REQUEST

Current Zoning: R-3 (single family residential)
Proposed Zoning: UR-2(CD) (urban residential, conditional)

Approximately 11.65 acres located on the east side of Mallard Creek Road, north of Governor Hunt Road, and west of David Taylor Drive.

The petition proposes a residential for sale community of up to 132 townhome style multi-family dwelling units together with accessory uses permitted in the UR-2 zoning district.

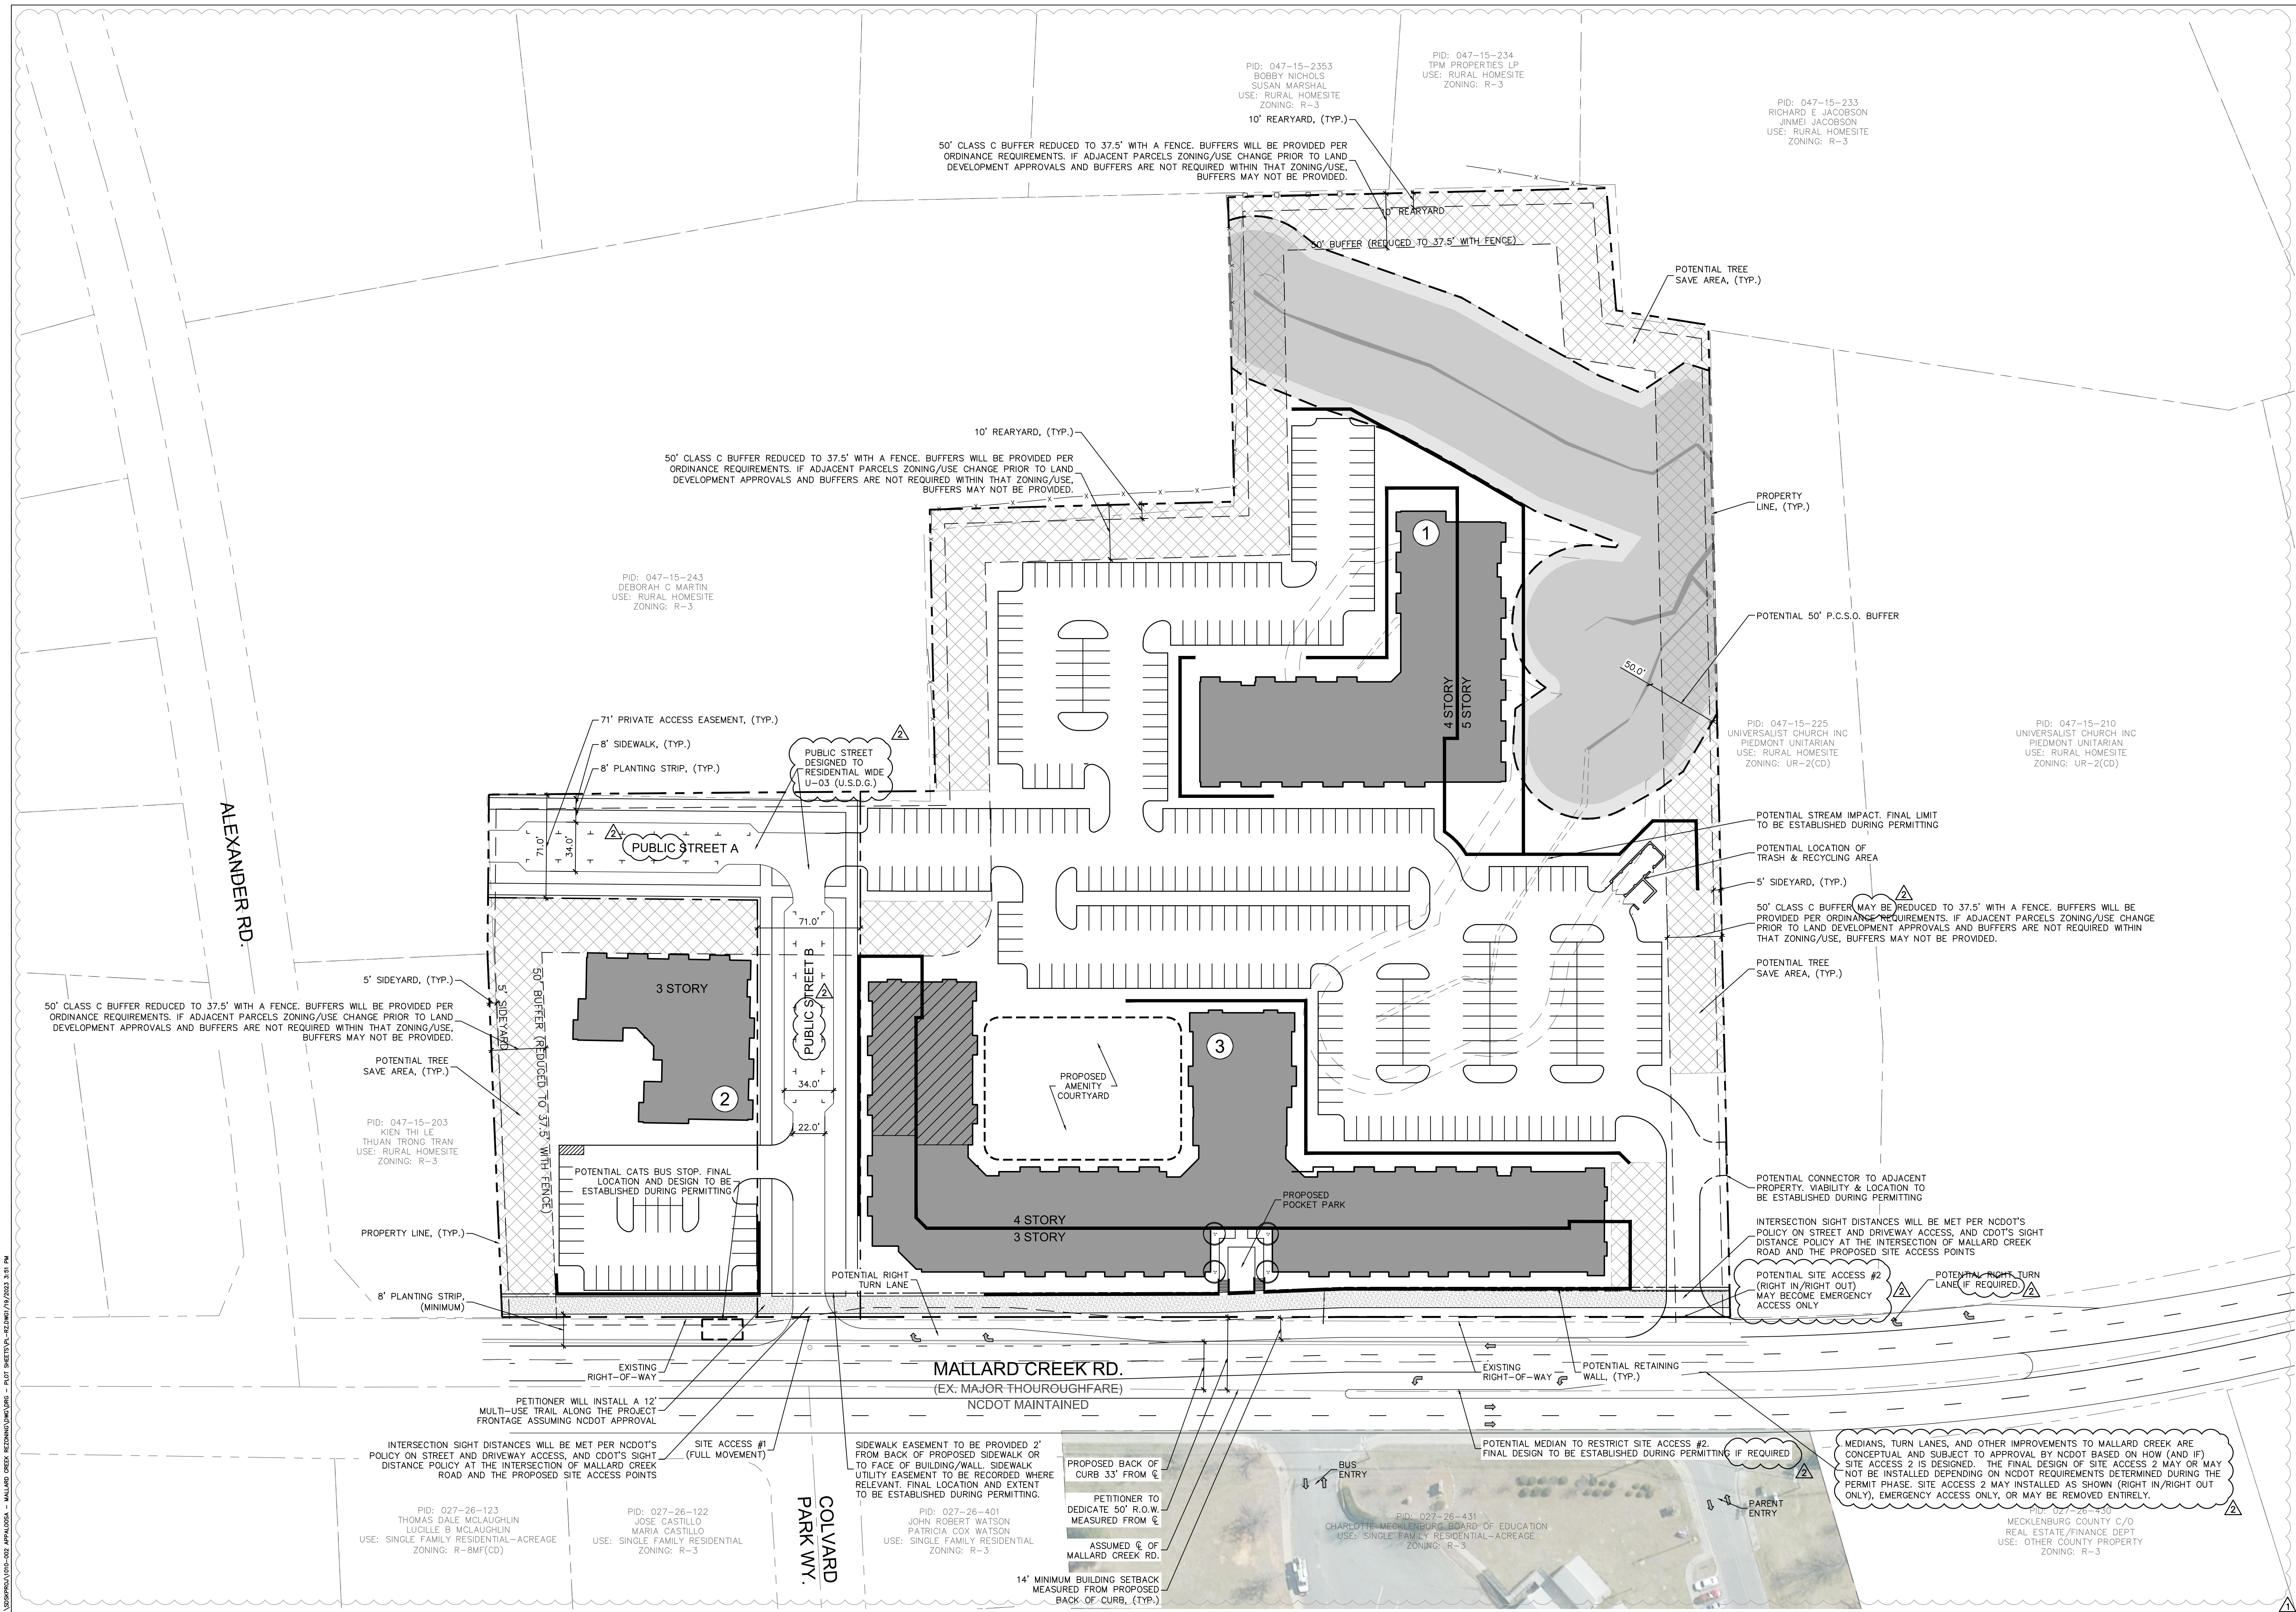
1. ~~Private Street A and Private Street B will both need to be public streets per coordination with subdivision. Remove all references to private access easements for Private Streets A and B.~~ Addressed
2. ~~Modify median to ensure full movement for development adjacent can be retained from parcels 04715225 and 04715210. What is being proposed will create a change of access for the development adjacent to property.~~ Addressed
3. ~~Either remove conditional note L or add as approved by NCDOT/CDOT at the end.~~ Addressed
4. ~~Remove word "potential" on callout for right turn lanes at site accesses. This is an NCDOT requirement. Add conditional note regarding right turn lanes at each site access. Label and dimension right turn lanes.~~ Addressed
5. ~~Remove "assuming NCDOT approval" on callout for 12-foot multi-use trail.~~ Addressed
